## Engineers Comments Regarding Surface Water Drainage

| <b>Application Reference:</b>   | <b>BR/67/25/PL</b>   | <b>Reviewer Reference:</b> | ADC/EXT5/AF |
| <b>Site Name:</b>               | 57 Queensway Bognor Regis PO21 1QN   |                            |             |
| <b>Application Description:</b> | Demolition of existing brick-built garages, removal of canopy structure, remediation of contaminated land and construction of 18 No. flats over 3 storeys with pitched roofs. This application is in CIL Zone 4 (Zero Rated) as flats. |                            |             |

Drawing:  
Existing and Proposed Areas  
Permeable and Impermeable

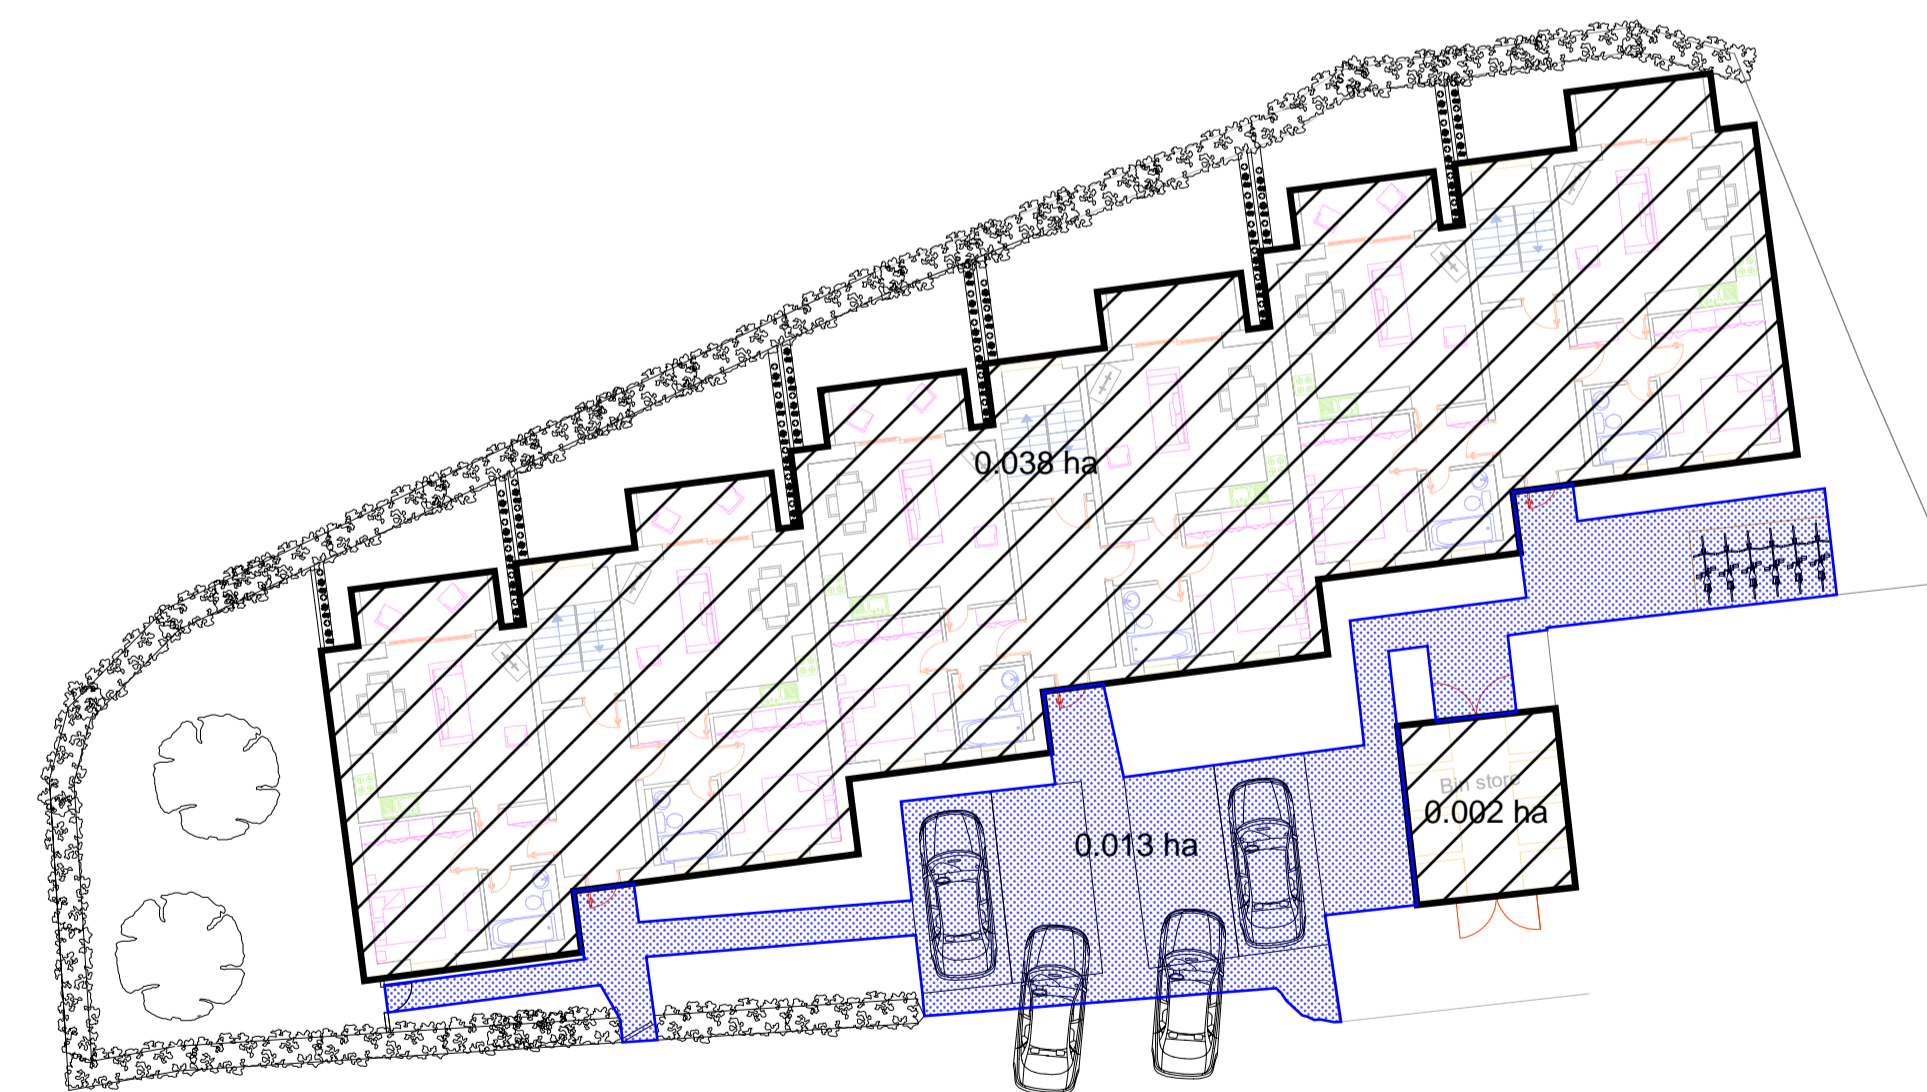
- 3.2. There are areas marked as permeable self-draining which are not acceptable and need to be included in the calculations as impermeable drained area. The drained areas should be confirmed on this basis.

- 3.5. A drained areas plan and summary which sets out totals including allowances for urban creep should be provided.
  - 3.6. The calculations will need to be updated and this is likely to affect the design peak flow rate and attenuation storage volumes.

Client:  
Project:  
57 Queensway, Bognor Regis, PO21 1QW  
Drawing:  
Proposed Drainage Strategy

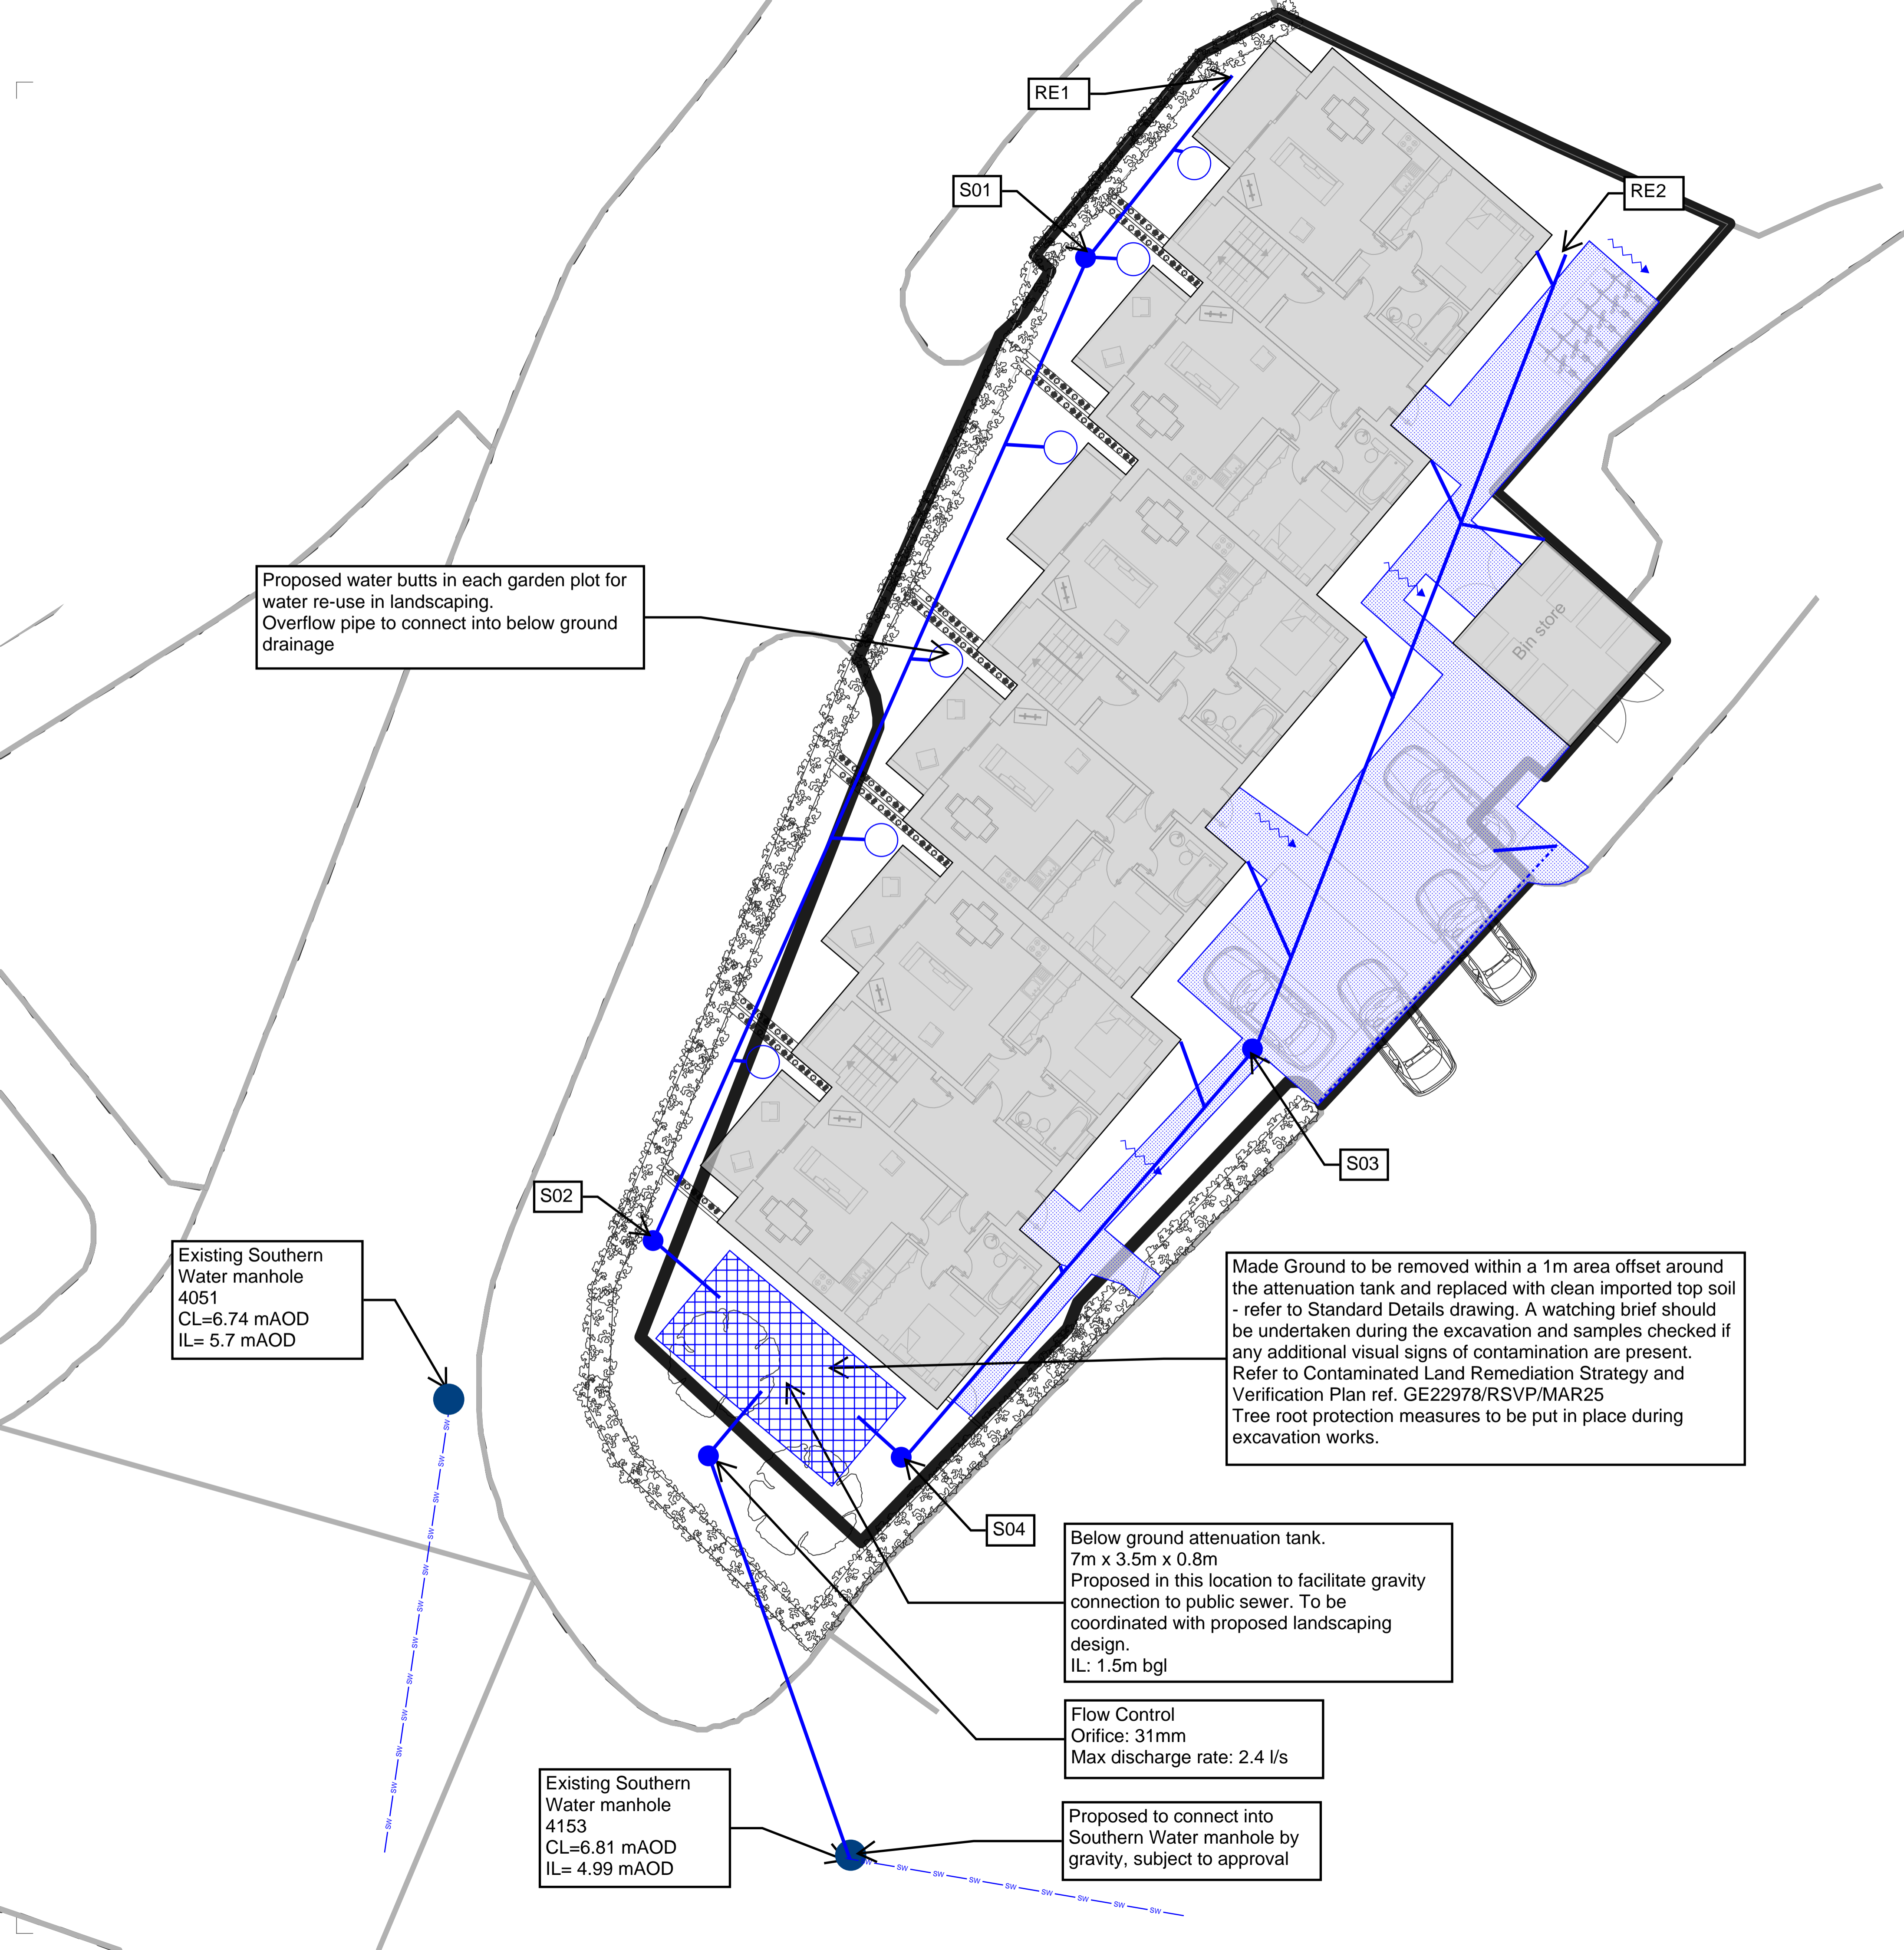
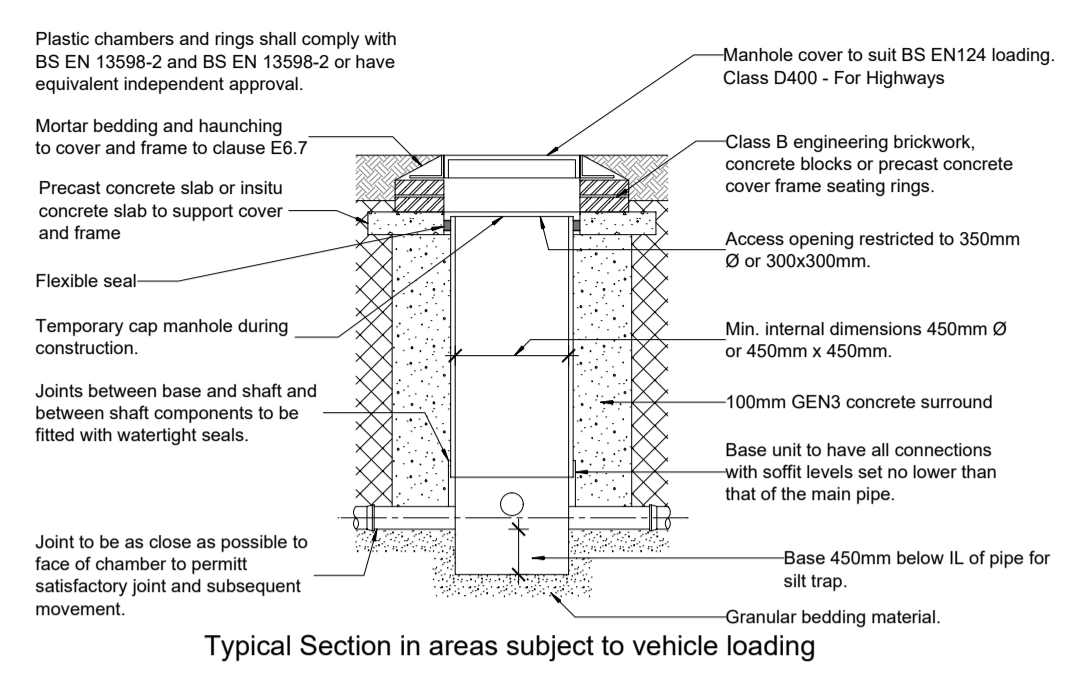
- 3.3. The drainage design layout does not currently include sufficient proposed levels information to demonstrate the design is feasible. Outline finished levels including FFLs and key external paved surface levels should be provided together with CL, IL, base of storage and any relevant top of storage levels.

- 6.5. Note there appear to be proposed trees positioned above the proposed attenuation storage. Advice should be sought to confirm that these trees are viable in the space and substrate constraints and that the trees would not damage the infrastructure in the long term.

**Permeable Paving - Infiltration**

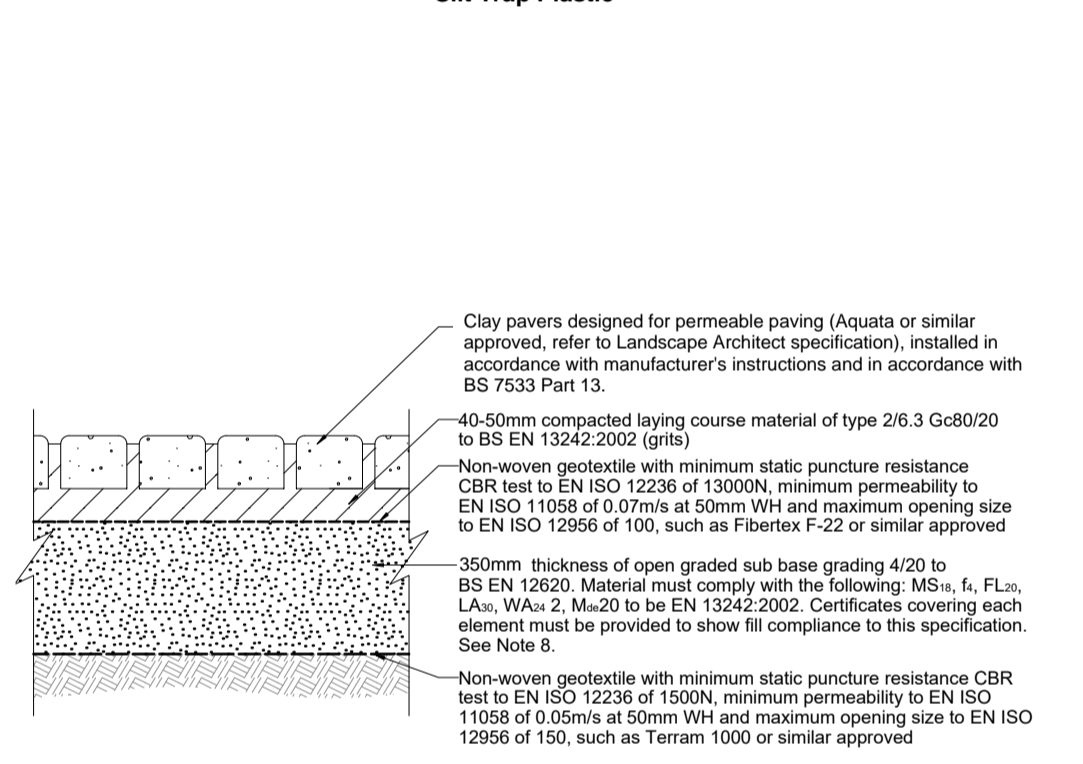
- 1.5. Note also the current construction details appear to show infiltration from the base of the permeable paving. This would not meet a requirement to retain 1m vertical distance from the base of the infiltration feature to groundwater.
